PLANNING AMENDMENT

Application No. **H14/0861/96**
Date registered **24 DEC 1996**
Case Officer

HORTICULTURAL COLLOCATION & DISTRIBUTION BUILDINGS WITH ASSOCIATED OFFICES

Description: Horticultural collation &
distribution building with
associated offices

GROUND FLOOR PLAN

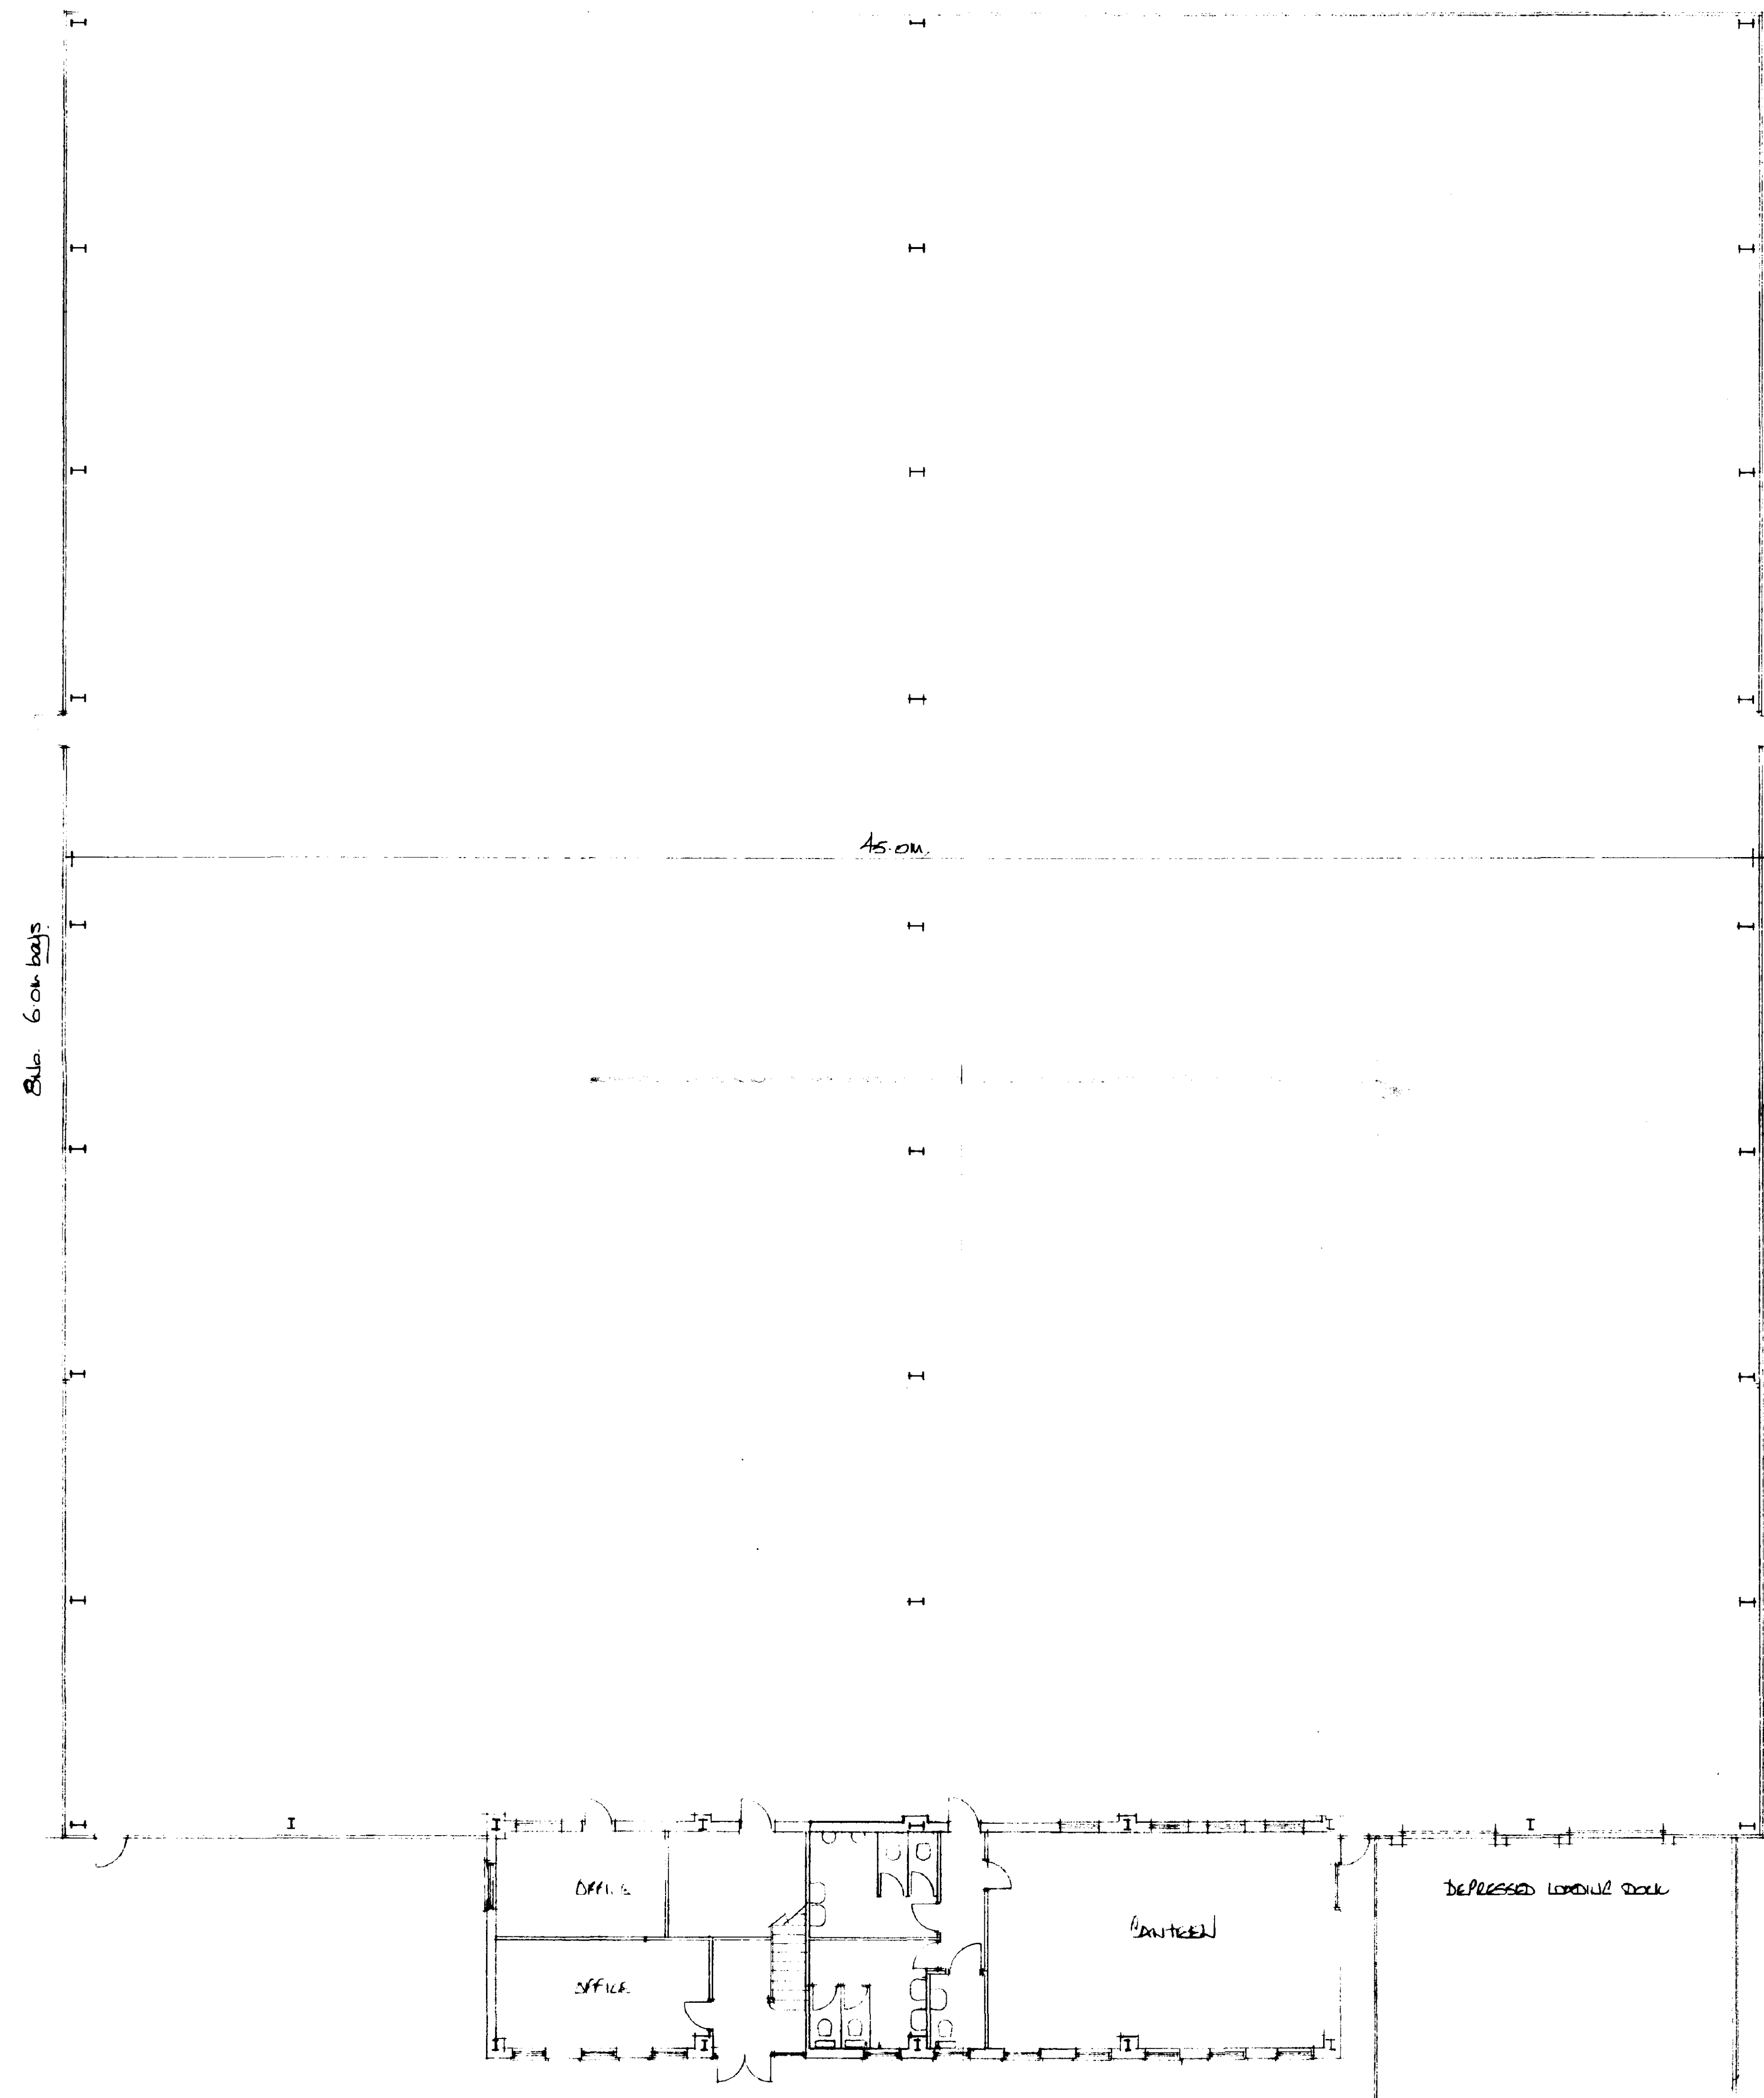
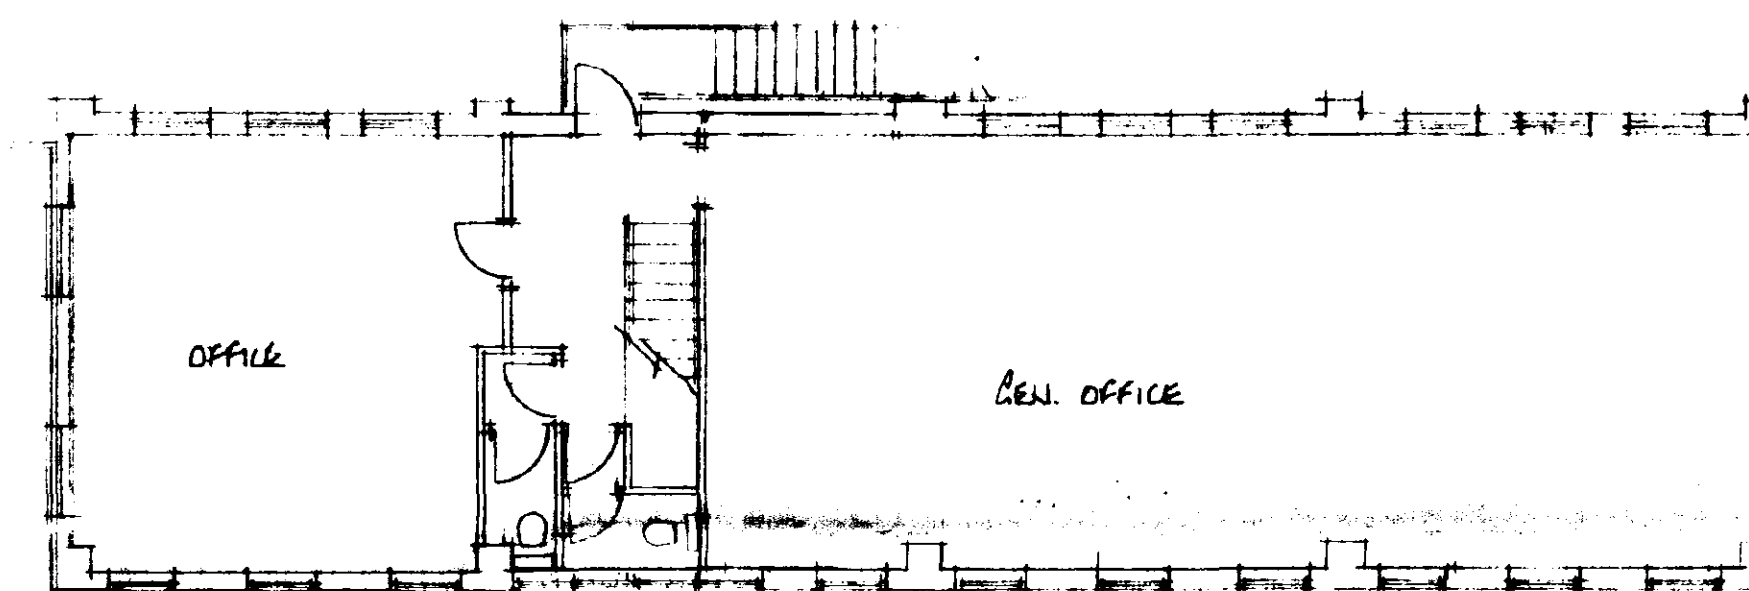
OFFICE LAYOUT - CREATION & AMENDMENT
GRADE HEIGHT INCREASED
